26 March 2013

Our Ref: 2013/096527
Your Ref: MP09_0153 MOD 3

RE Section 75W Modification for Minor Internal and External Design Changes, and Deletion of Conditions to Dr Chau Chak Wing Building at 14-28 Ultimo Road, Ultimo (MP09_0153 MOD 3)

ZL1-1.02

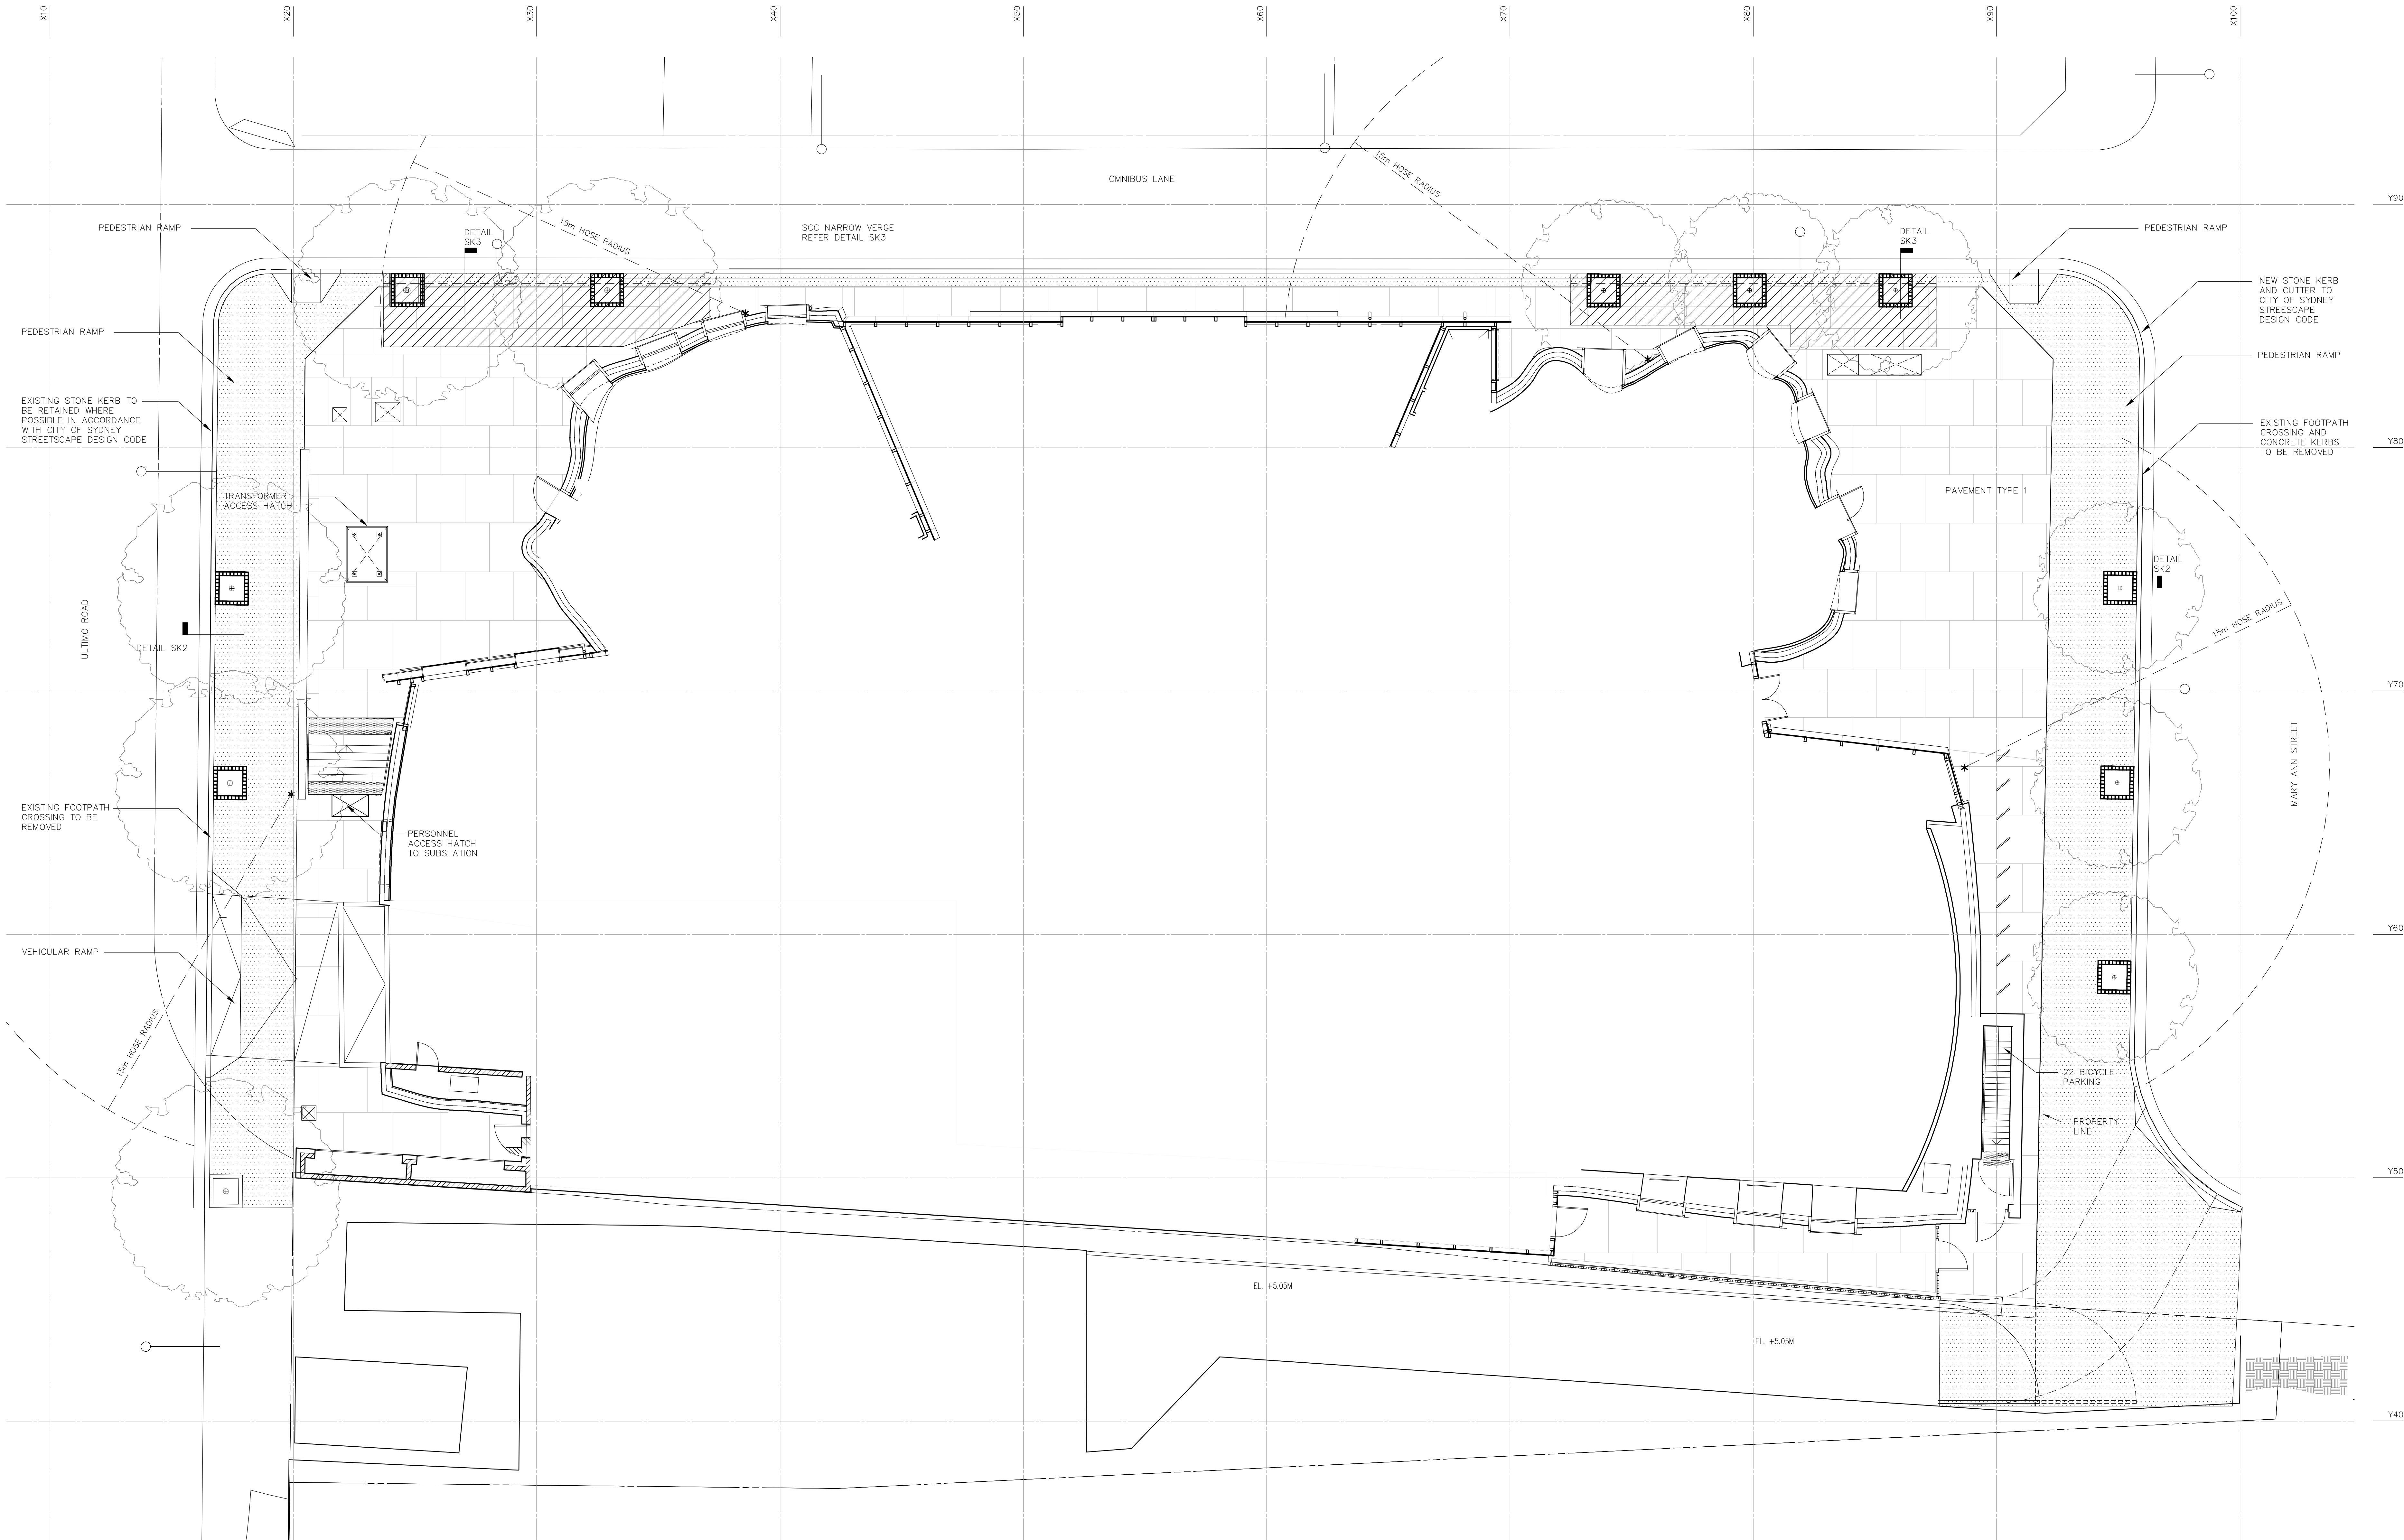
The street trees are shown as being located within the site boundary of the development and therefore under the control of the applicant. However, the Section 116 proposal to narrow Omnibus Lane, if successful, will locate the street trees wholly within the Council footway.

The removal of one tree along Omnibus Lane has been proposed in consultation with Council's Public Domain Unit in order to provide an acceptable increased width between trees. Accordingly, the proposed removal of the tree is supported by the City.

The stone setts around the trees are requested to be removed as the City no longer requires this detail. Should the Section 116 application not be successful, the applicant should consider widening the asphalt portion of the footway so that the tree pit is within a single material rather than two separate materials.

TITLE
GROUND LEVEL
FLOOR PLAN

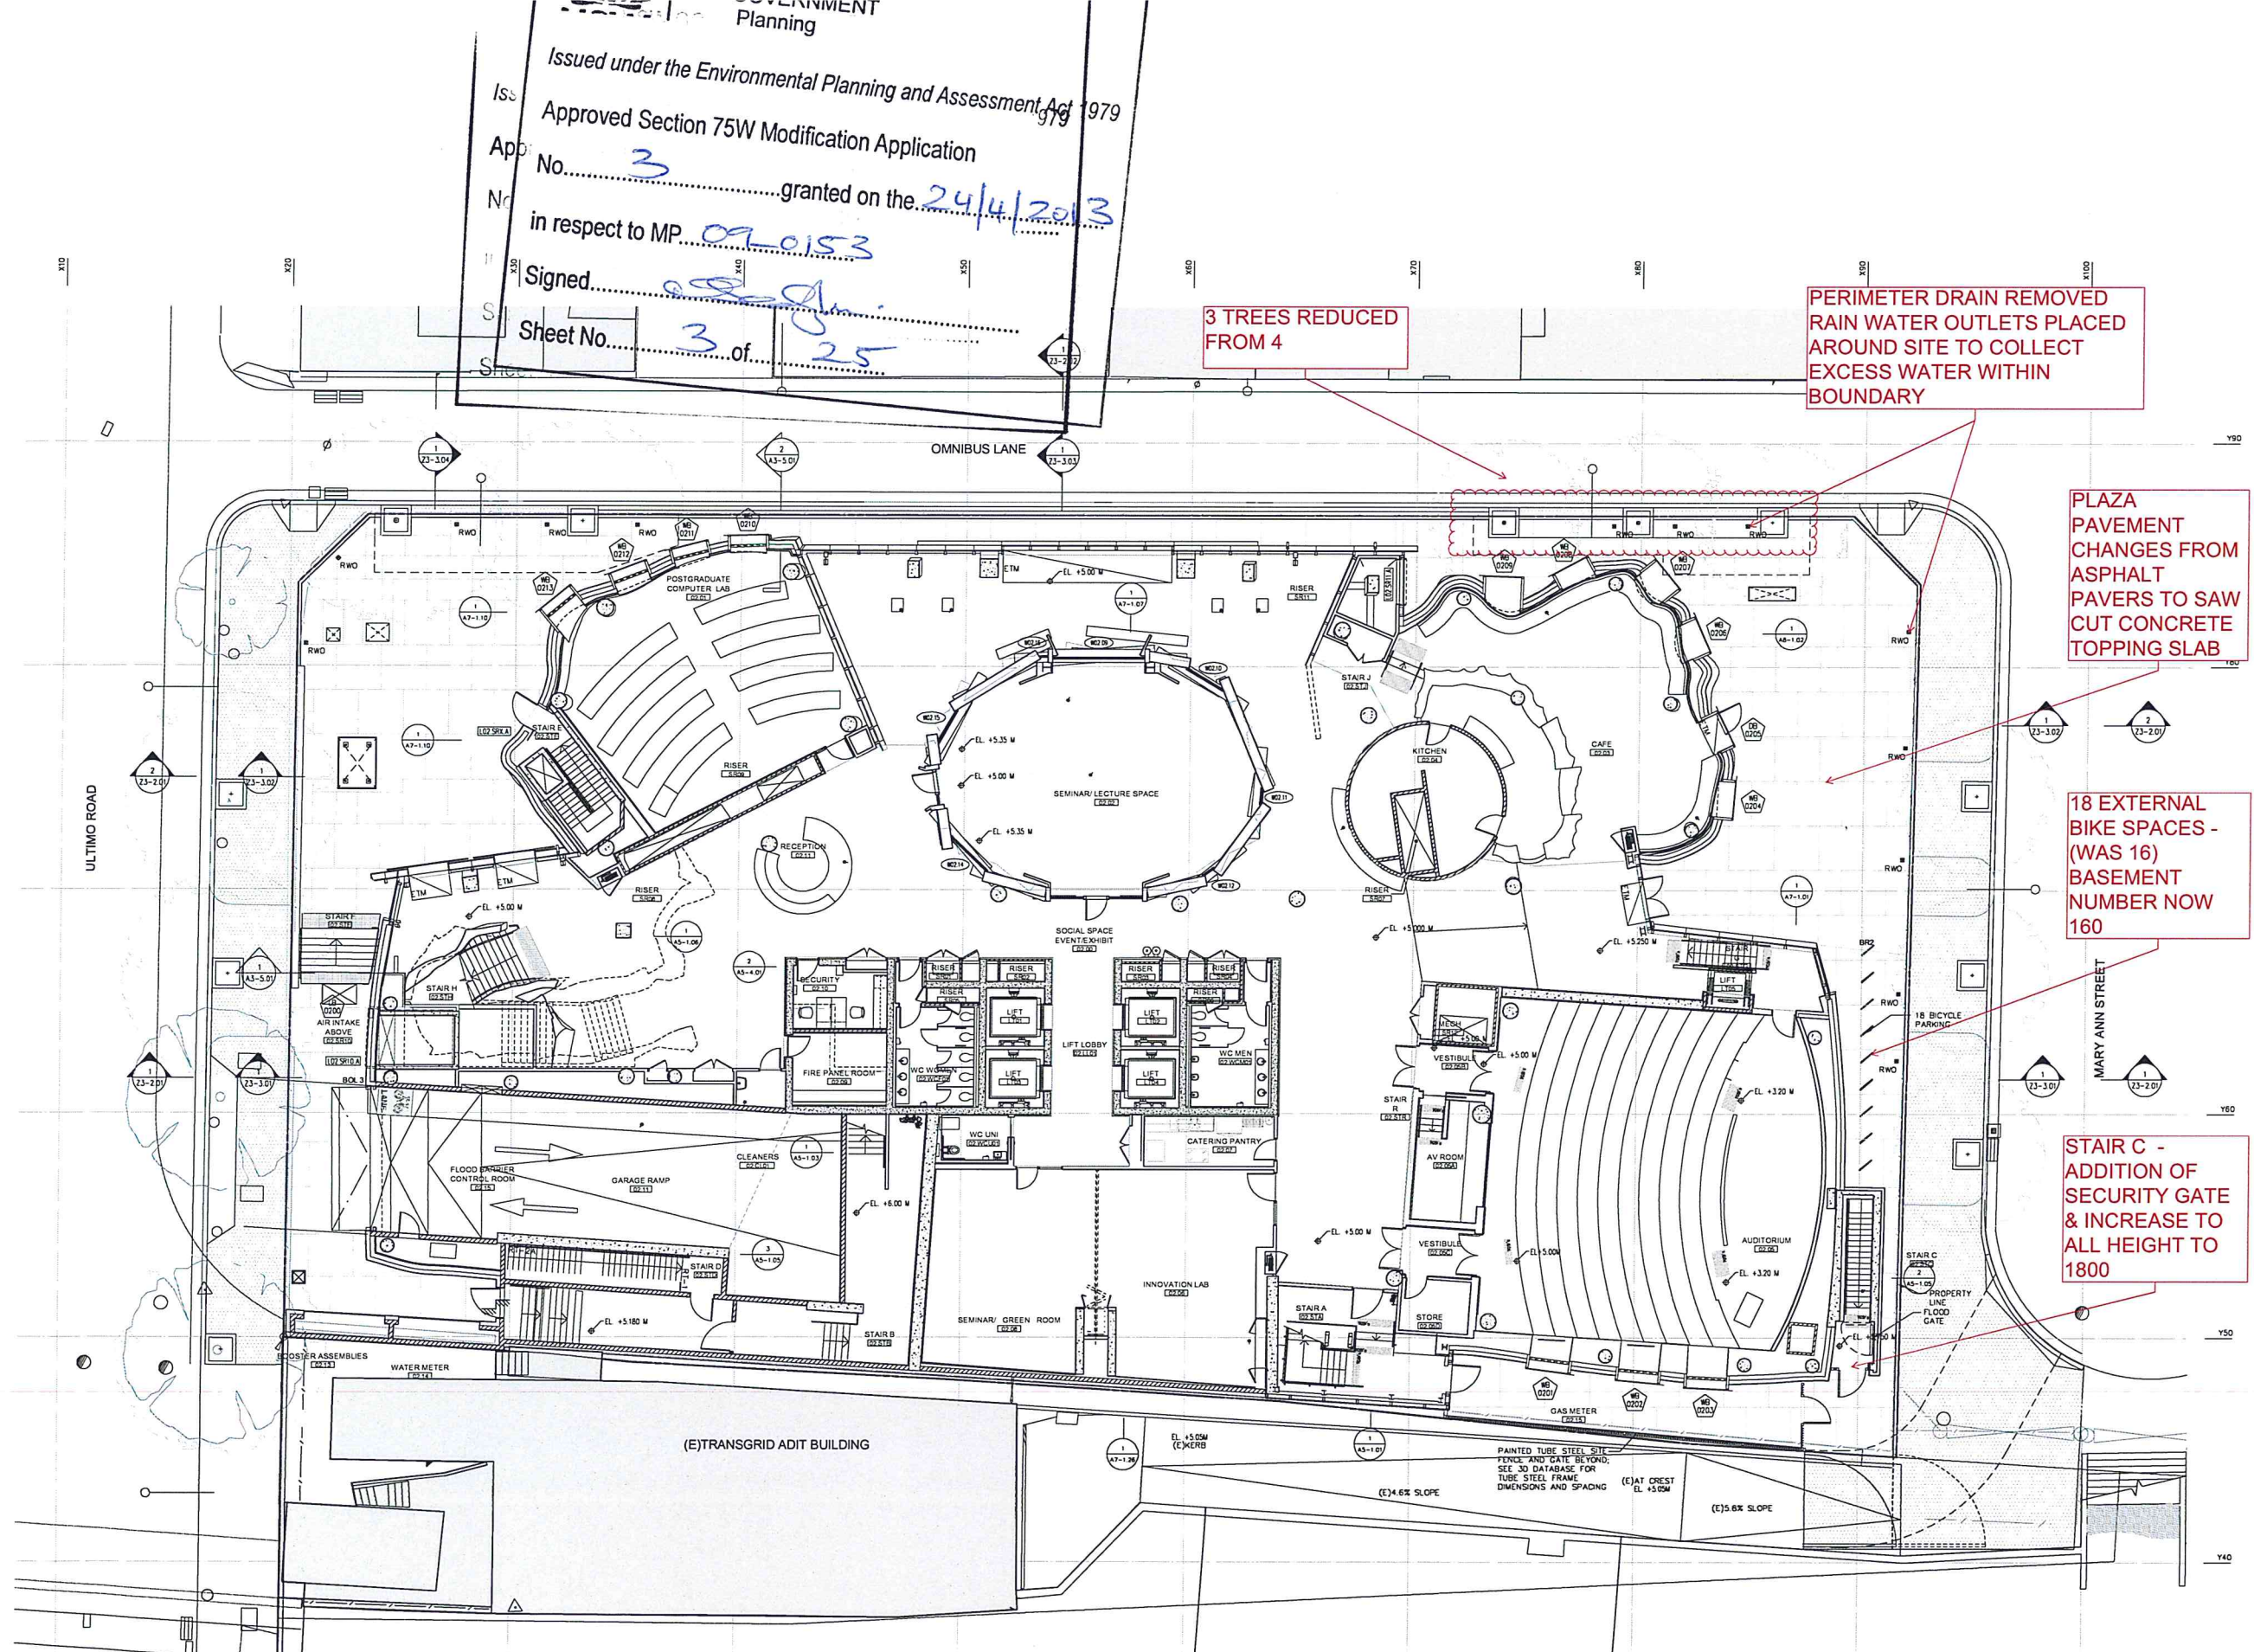
The stormwater and drainage system has been redesigned to provide a series of pits (RWO) throughout the privately owned paved areas to capture collect any excessive surface stormwater runoff from within the property boundary. Council accepts that the system will address ordinary rain events but in cases of severe storm events it is not the case that the RWO could collect all the water and some will cross the footway into the kerb and gutter.

It is accepted of most developments, with some private paved areas around the building, that some stormwater runoff will cross the public footway and enter the

City's kerb and gutter for collection. It is not expected that the small amounts of additional runoff will overload the City's systems.

Council's Stormwater and Drainage Unit supports the conclusions in the applicant's Flood Study.

The proposed change in surface material to saw-cut concrete within UTS' land does not exactly align with the adjoining asphalt footway; however, Council accepts that the material is acceptable given it is on private land.

No objection is raised to the redistribution of bicycle parking around the site, so long as there is no net reduction in bicycle parking spaces.
